Environmental Impact Statement (EIS)

Raising Warragamba Dam

ID: SSI-8441

Submission

Figure 3-2. Relative contribution different river catchments in range of Hawkesbury-Nepean Valley floods

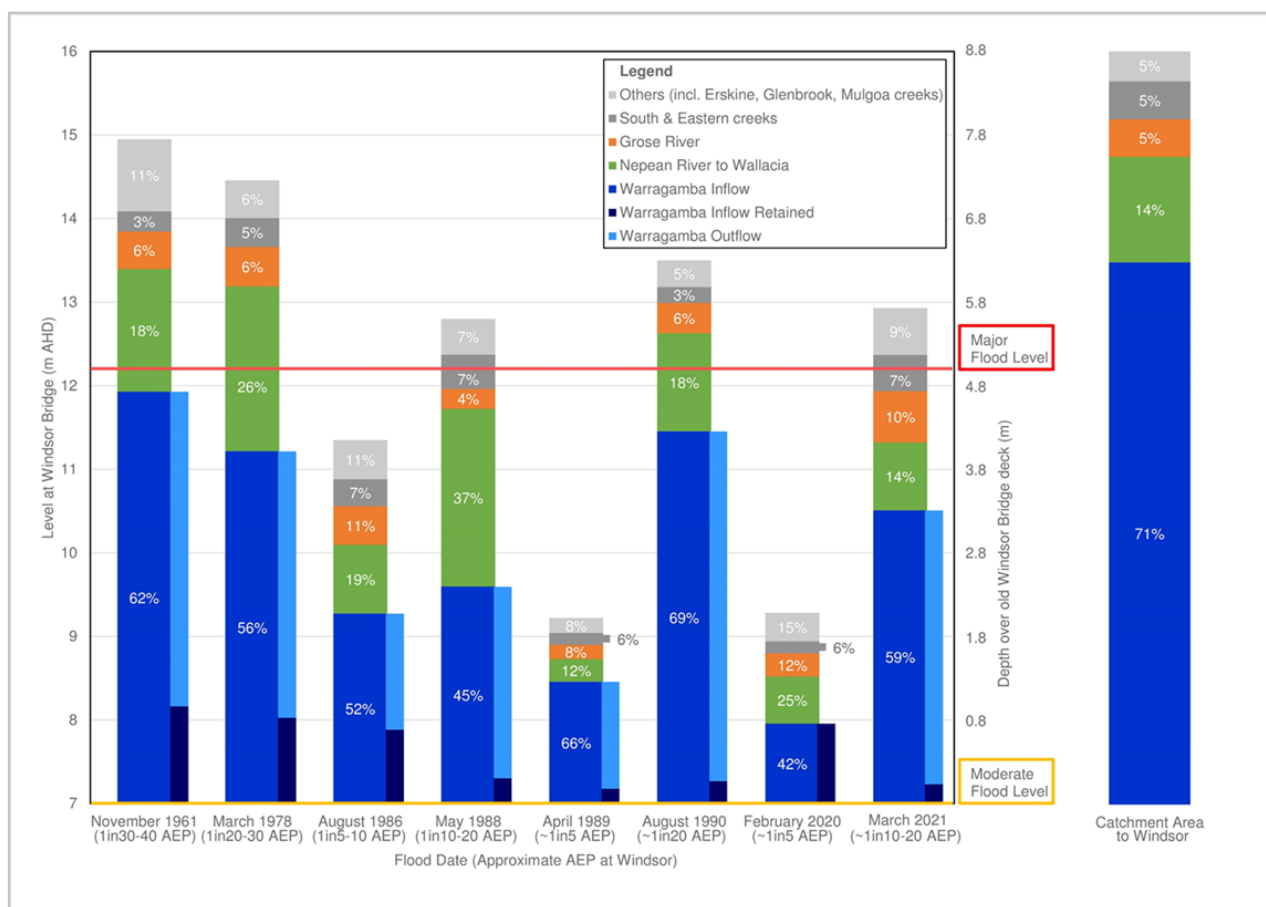
Video of Flooding and Hydrology of the Hawkesbury Nepean Valley states 70% water coming from the Warragamba River, 37% from the Nepean River, 11% from the Grose River and 7% from the South Creek catchment.

My question is, why wasn't the effect of a flood coming from the Nepean independently without influence from the Warragamba put forward within this EIS.
